14th March 2011

Our Ref: LU/18/11

**Erection of 2 No. 3 bedroom town houses
Rear 27/29B Surrey Street, Littlehampton**

DRG. NO. 3222/2

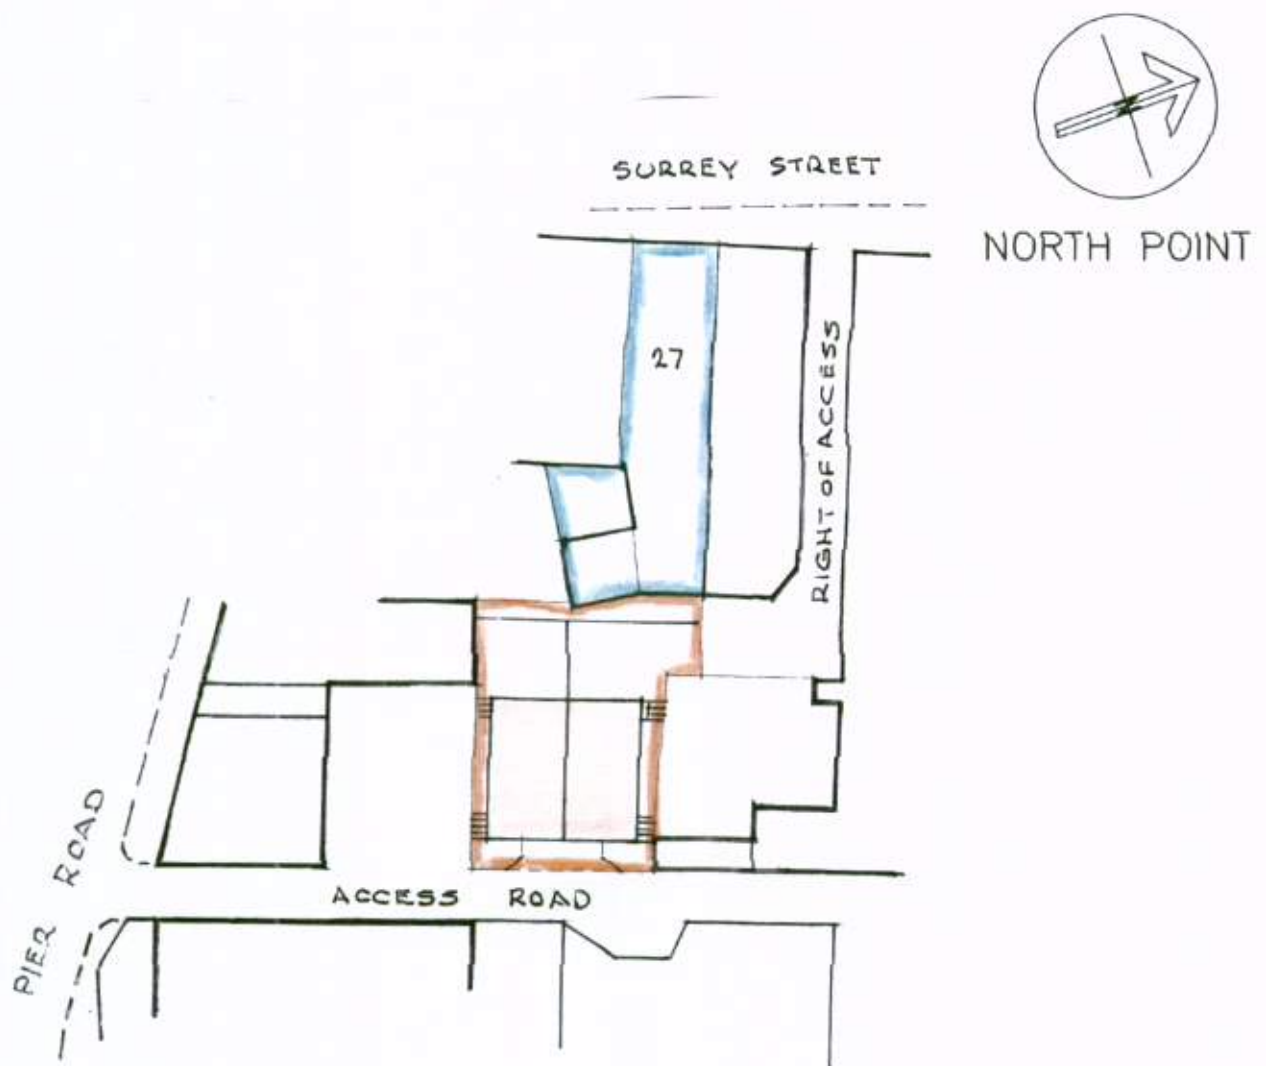
The application form does not refer to any previous discussions. The proposal is an improvement on the previous refusal, but I still do not consider that two units on this limited site area, with no road frontage would be acceptable even if the flooding issues could be addressed and affordable housing contributions made.

I see little merit in a meeting to discuss the proposal as it stands, since more than a few minor changes would be required to address my concerns. The application will therefore be determined as submitted and recommended for refusal and you will have the right of appeal following any refusal. You can of course request your agent withdraw the application. Should your agent wish to discuss a revised scheme following refusal or withdrawal I would be prepared to discuss revisions and comment on any reduced scheme prior to re-submission. I remain to be persuaded that more than one unit could be accommodated on the site.
